Rezoning Transportation Analysis

Petition Number: 2023-164

Date	Description
01-24-24	First Review (JP)
02-21-24	Second Review (JP)
03-20-24	Third Review (JP)
04-03-24	Trip Generation
07-02-24	Fourth Review (JP)

DRAWING NO.: **RZ-01**

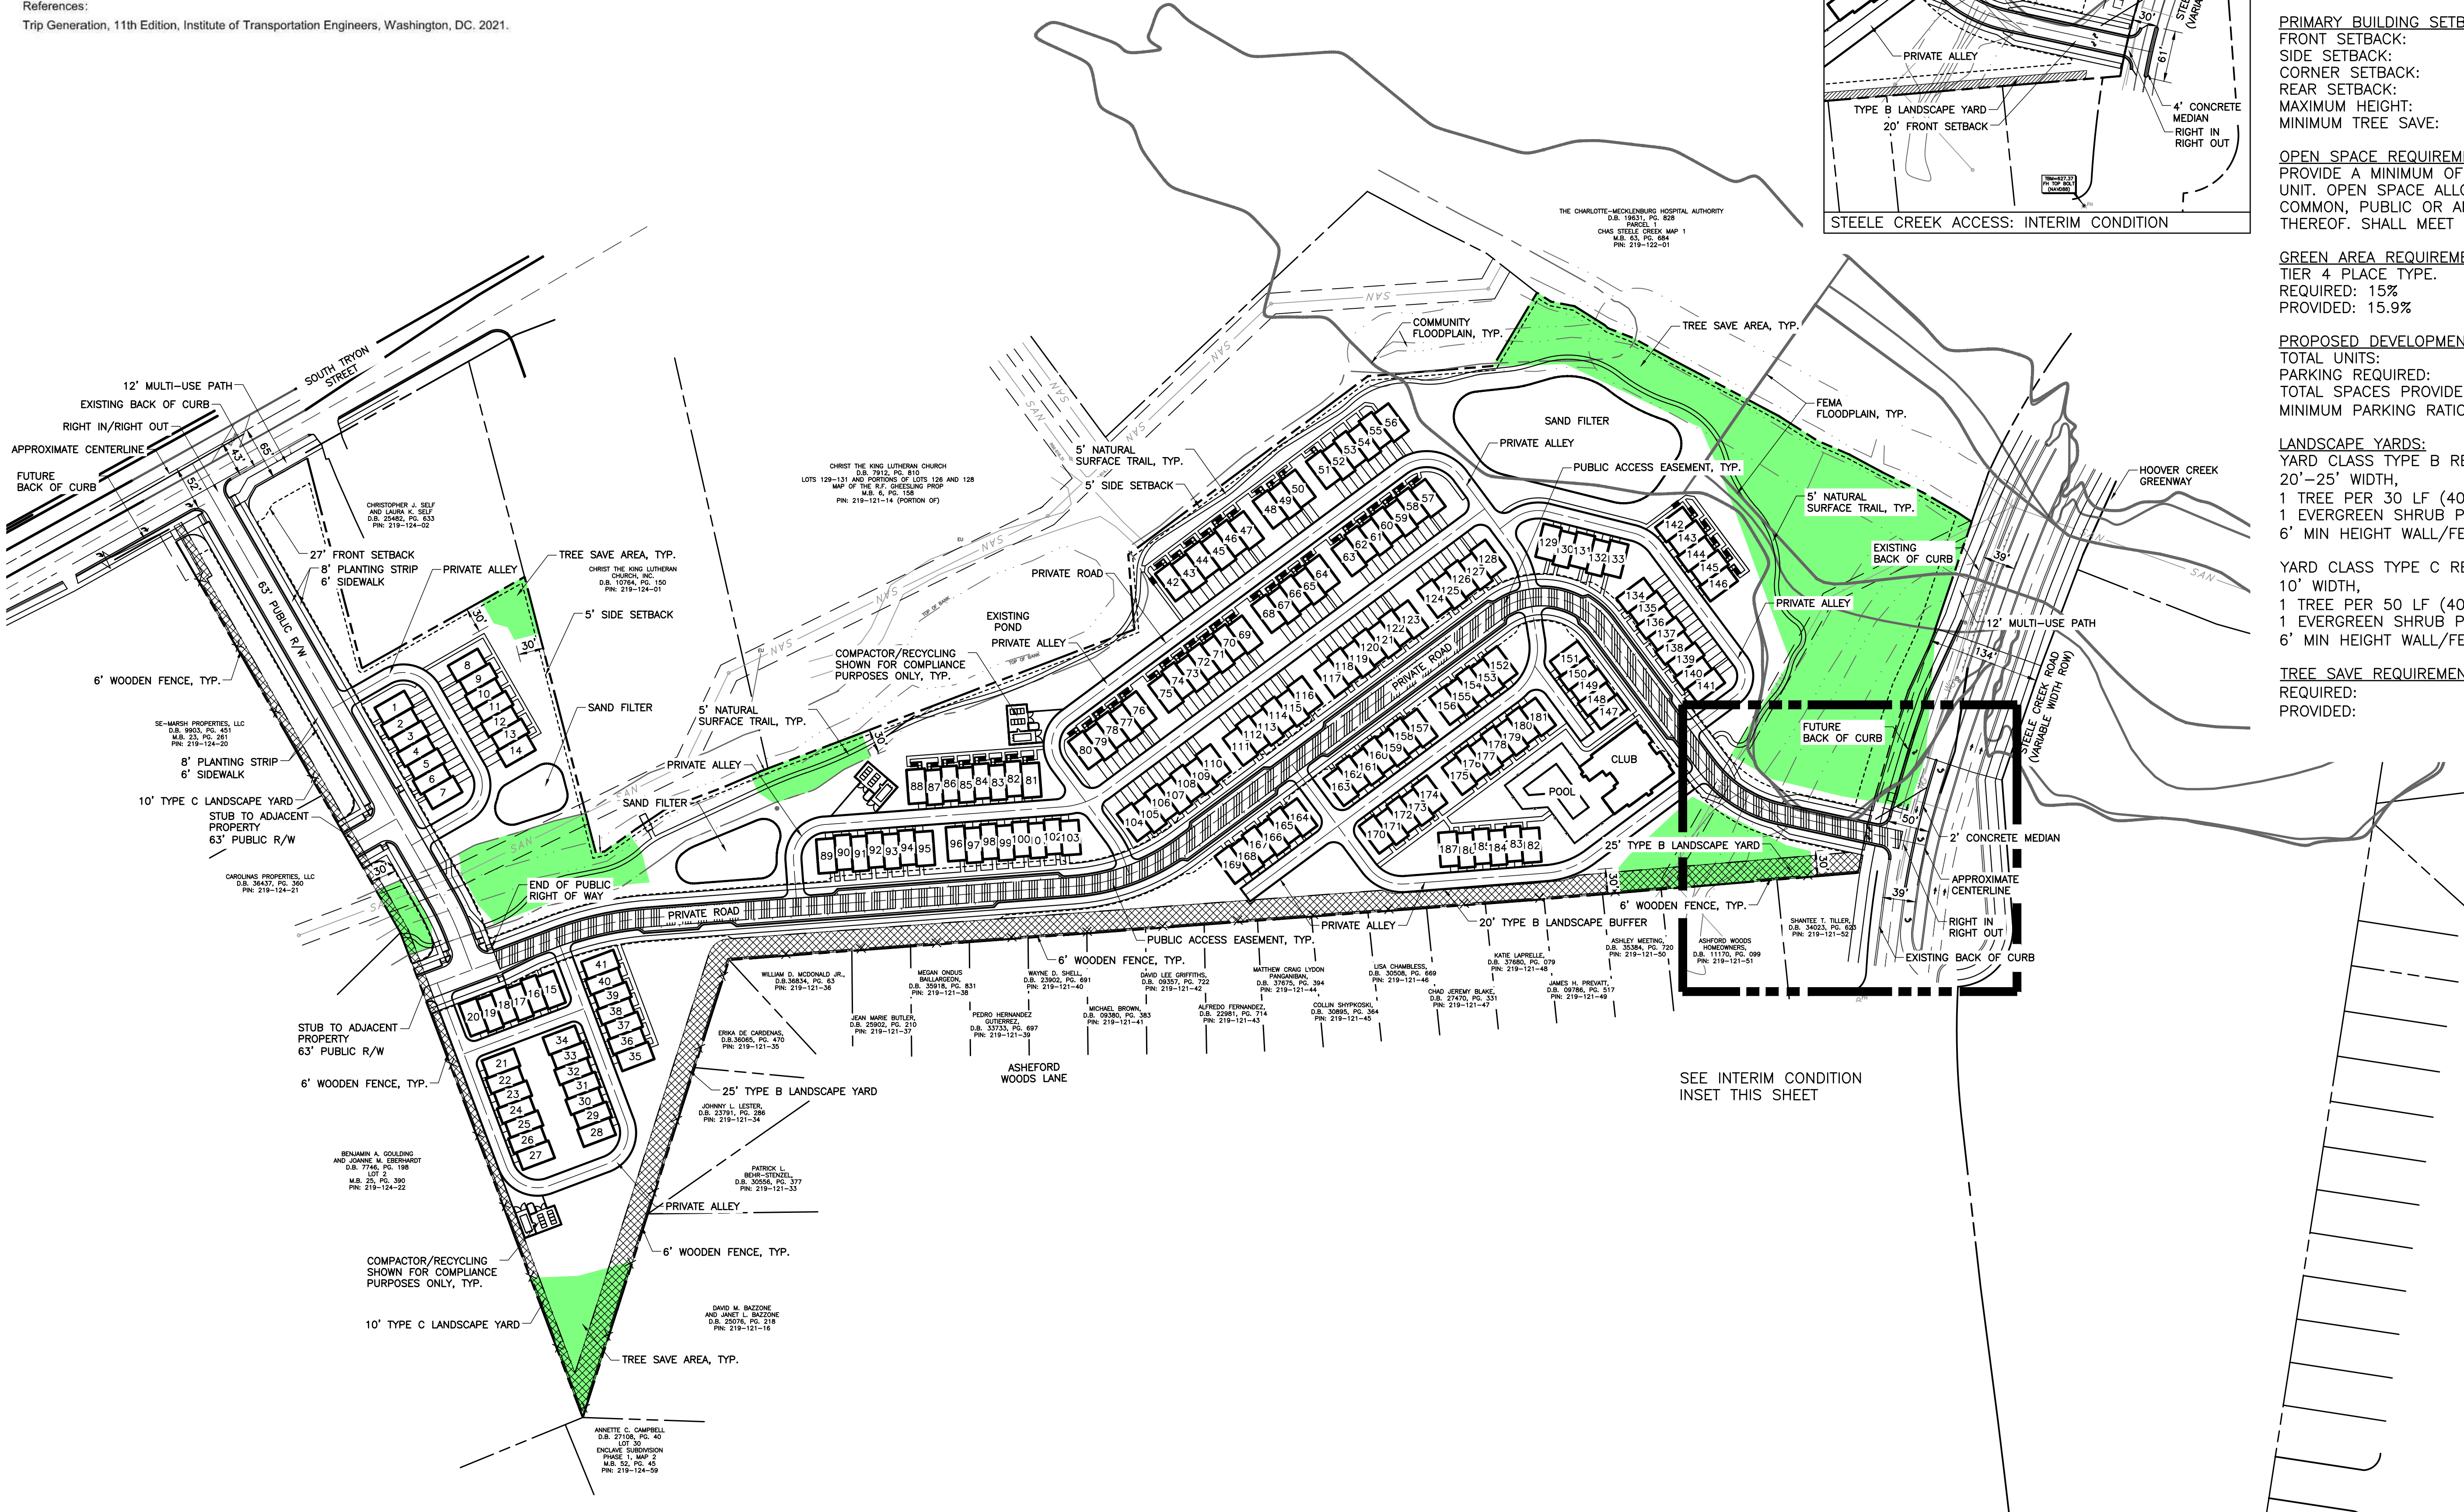
Outstanding Comment 2.21.24: Label and dimension the curb and gutter from the centerline for each road on the site plan.

3. ~~Revise site plan to label and dimension the streetscape, label and dimension the right-of-way, back of curb, and future back of curb (if applicable) from the centerline on Tryon Street, Steele Creek Road, and proposed public street.~~

~~Clarifying Comment 2.21.24: These must be labeled on the site plan.~~

4. ~~Revise site plan to show interim condition on Steele Creek Road and screen in the final condition to be installed by NCDOT as part of the Steele Creek Widening Project.~~

~~Clarifying Comment 2.21.24: Callout concrete median on Steele Creek Road on the inset. Label and dimension the median length.~~

~~Clarifying Comment 3.20.24: Median should be shown to extend to 50' past radius returns at the new street connection.~~

5. ~~Revise site plan to shift Tryon Street access further from existing driveway.~~

Clarifying Comment 2.21.24: Show multi-use path on the site plan and call it out. Multi-use path must be in the right-of-way, revise conditional note.

8. ~~New Comment 2.21.24: ROW should not be terminating in the middle of the road. Continue the ROW to the end of the street, capturing the street stubs.~~

9. ~~Revise site plan and conditional note(s) to commit to provide a public access easement for the Private Road (UDO 31.1 (A)(1)).~~

~~Clarifying Comment 2.21.24: Revise site plan to call out the public access easement. Use a different line type for easement versus ROW.~~
